Please ask for: Sian Eggington
Email: sian.eggington@terraquest.co.uk
Telephone: 0121 234 1390
Our Ref: LU/49/22/HH
Your Ref:
Date: 23rd February 2022

Application for Planning Permission for Works or Extension to a Dwelling

Development: Single storey rear extension.
Location: 27 Clun Road Wick Littlehampton BN17 7DZ

SITE BLOCK PLAN (1:500)

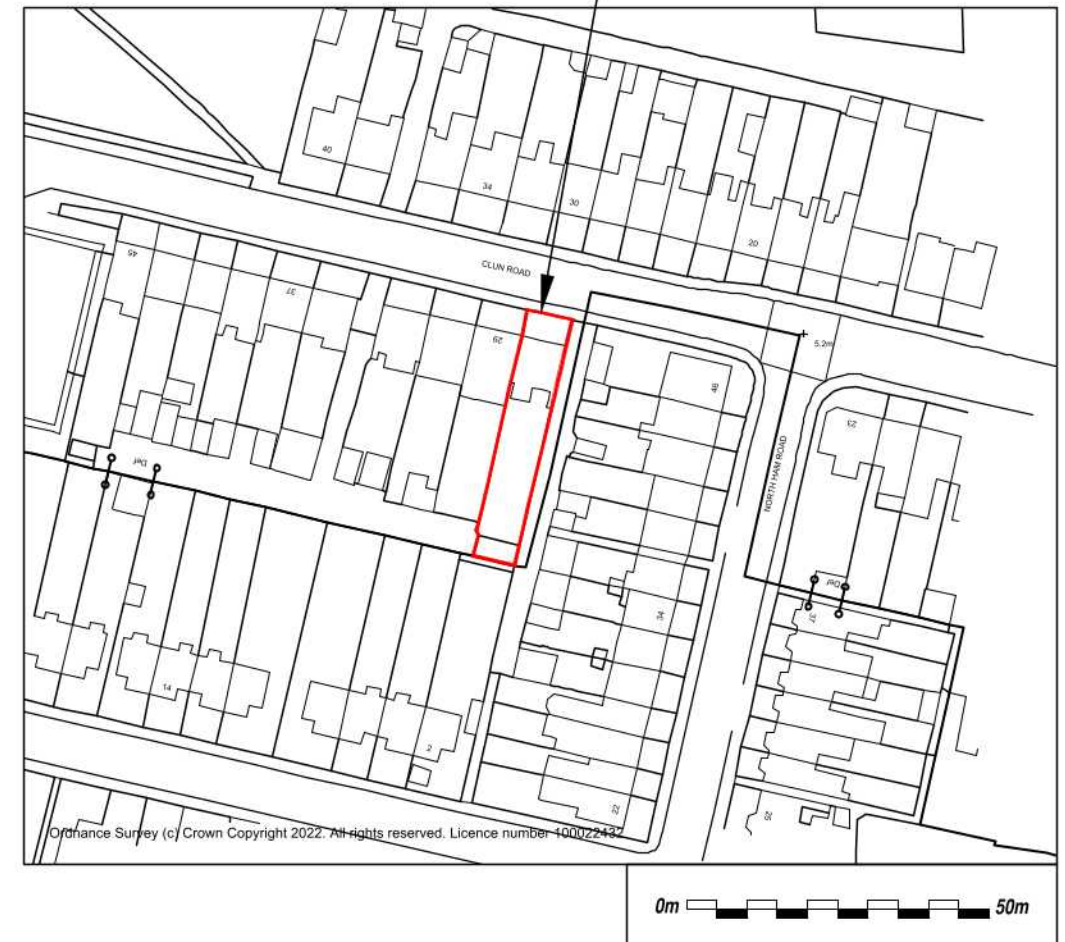
Dimensions: You are required to include dimensions on the block plan from the proposed extension(s) to ALL site boundaries. Please amend.
